# Rezoning Transportation Analysis

Petition Number: 2019-146

Date	Description
11-21-19	First Review
12-23-19	Second Review
02-17-2020	Third Review

PROPOSED SITE PLAN
A-1.1
OF: TWO

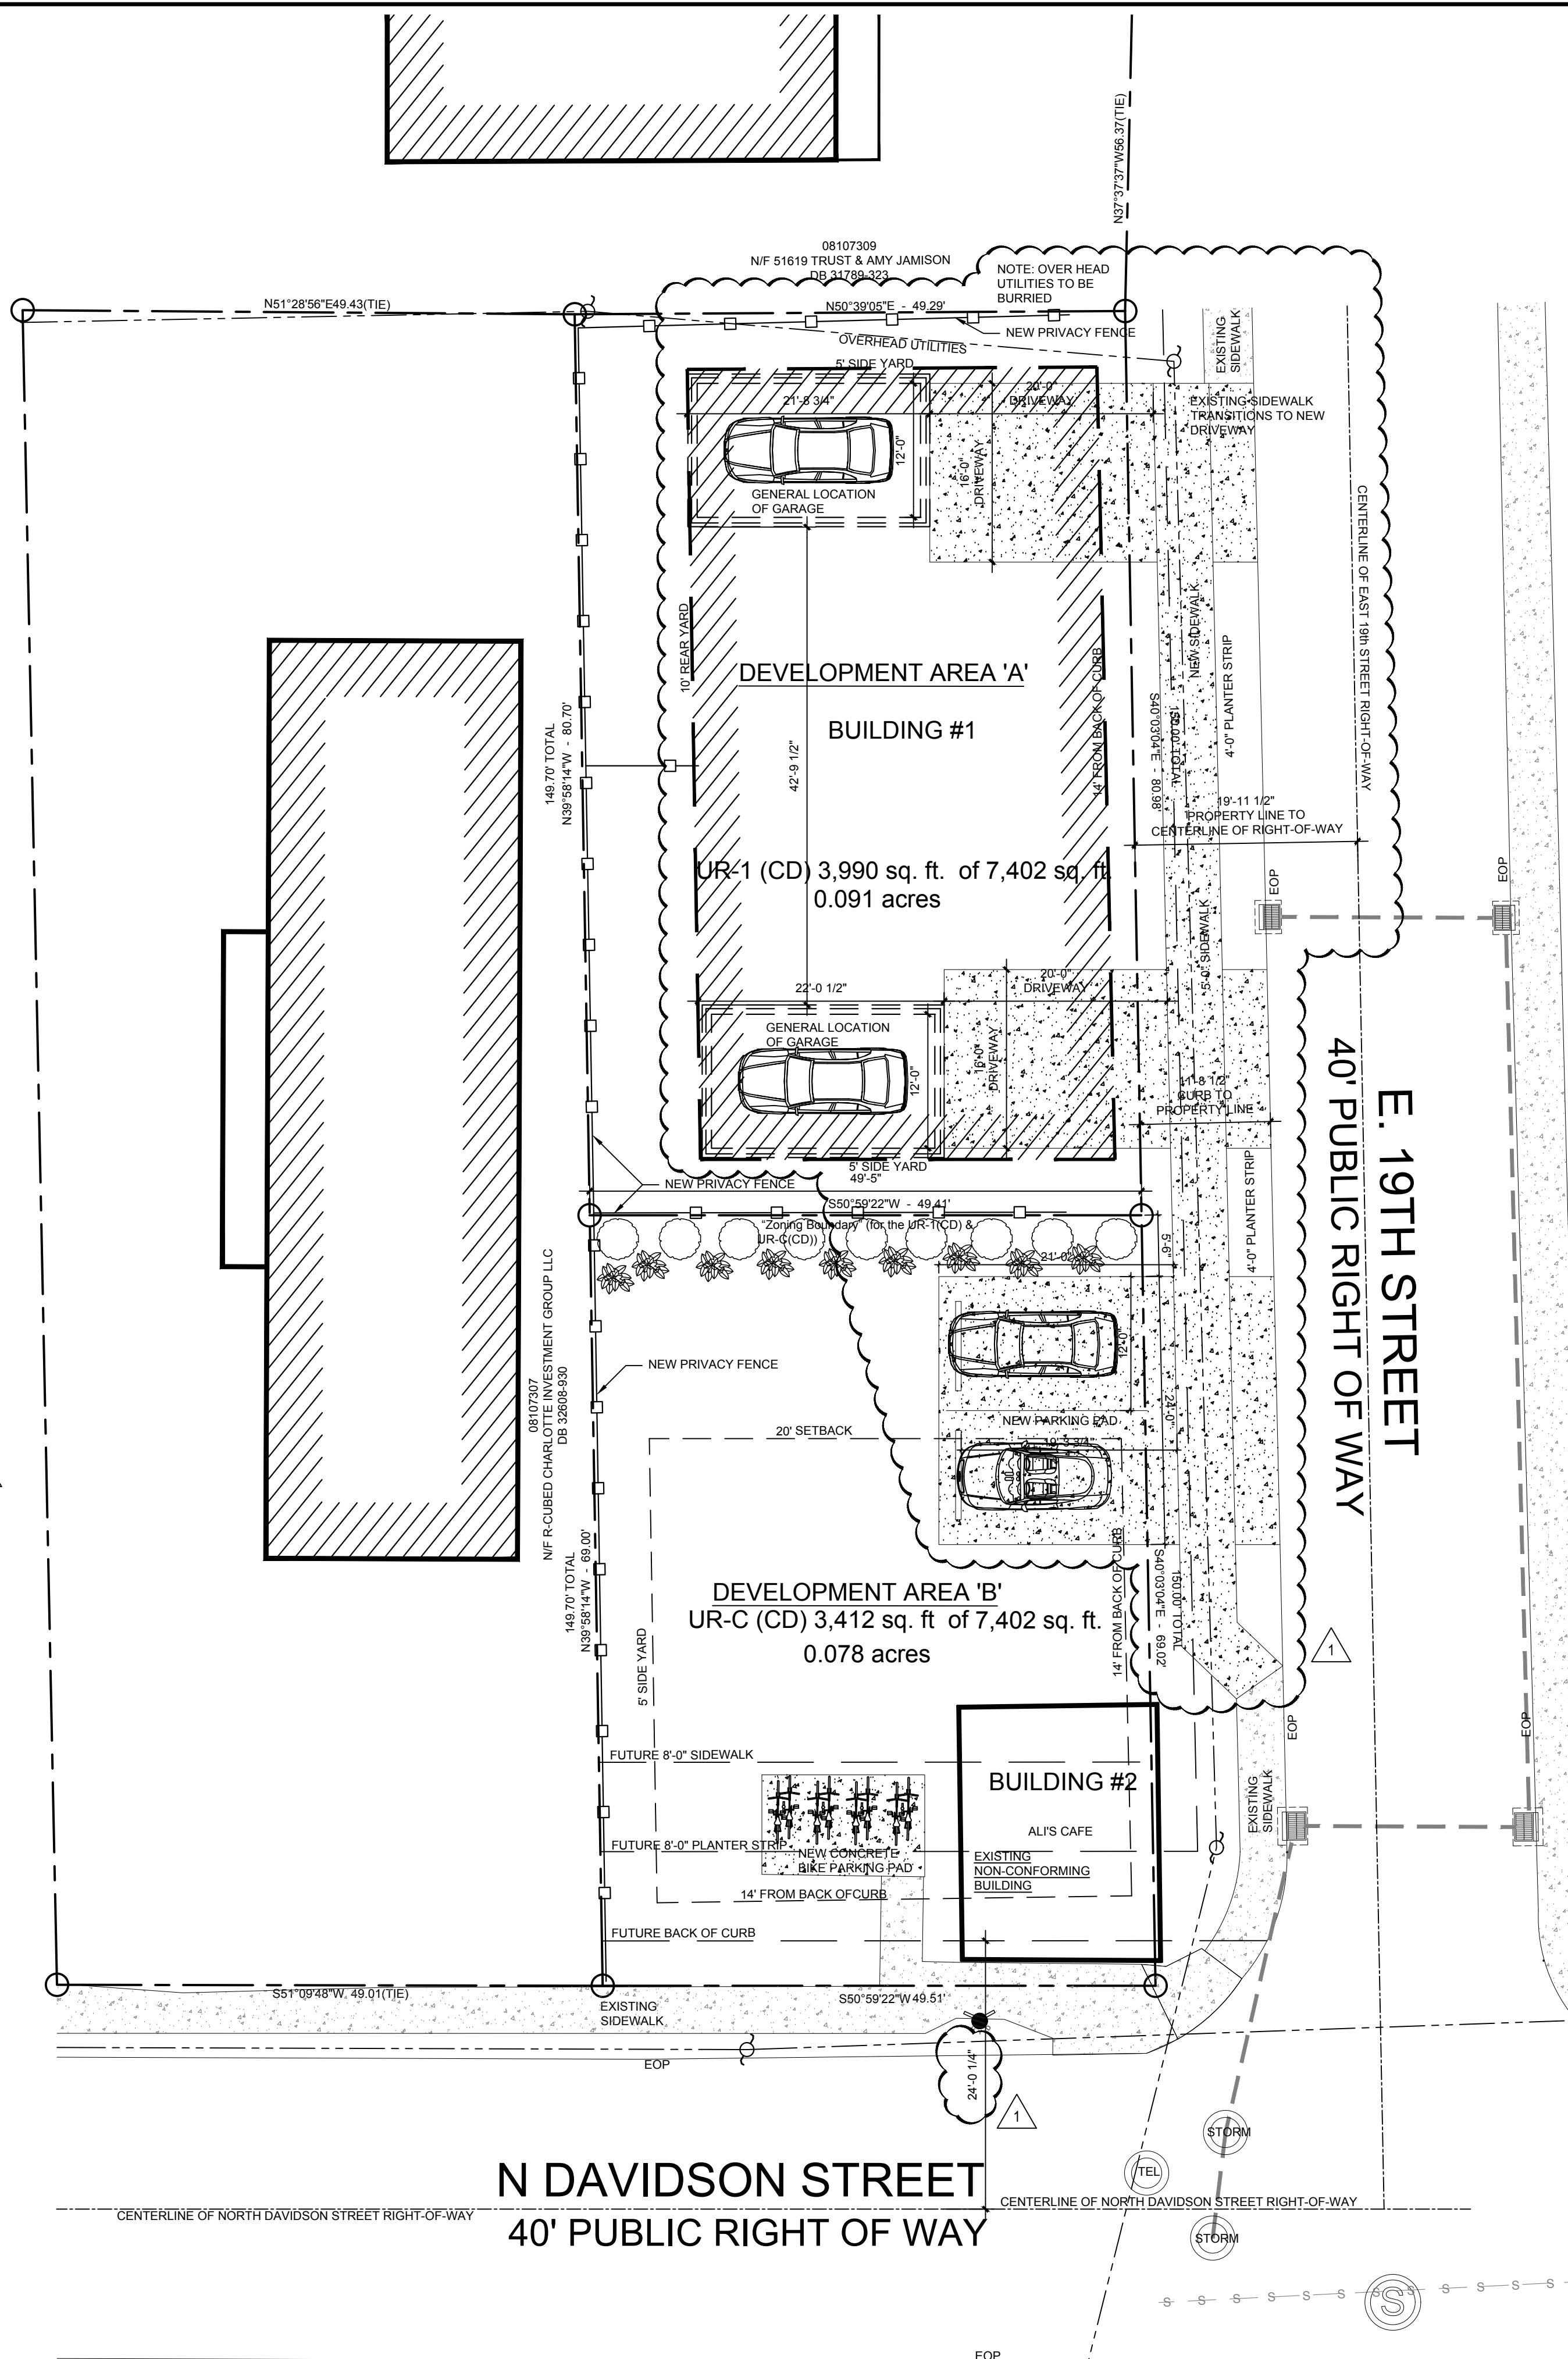
1. **Curbline** The proposed zoning district has a setback measured from back of the existing or proposed future curbline.
  - a. ~~19<sup>th</sup> Street:~~ The future location of curb and gutter is in its existing location.
  - b. **Davidson Street:** The future location of curb and gutter is 24' from centerline to back of curb.

The site plan should show the curb and gutter labeled and dimensioned from the centerline for each road.
2. ~~**Traffic Study** A Traffic Impact Study is not necessary for the complete review of this petition. If the during the permitting process the site generates more than 2500 daily trips, then a traffic study will be required.~~

3. **Comment updated based on site plan 12/17/19:** CDOT is requesting the petitioner update the site plan and conditional notes to show and dimension 8' planting strip and 5' sidewalk along 19<sup>th</sup> street as generally depicted on the *originally* submitted site plan.

5. The petitioner should revise the site plan to add a note specifying dedication and fee simple conveyance of all rights of way to the City before the site's first building certificate of occupancy is issued. CDOT requests right of way set at 2' behind back of sidewalk where feasible.

- a. **Technical Correction based on site plan 02/05/2020:** The petitioner has copied and pasted the exact words as stated above, please update to state that the petitioner is actually going to complete all transportation improvements...etc.
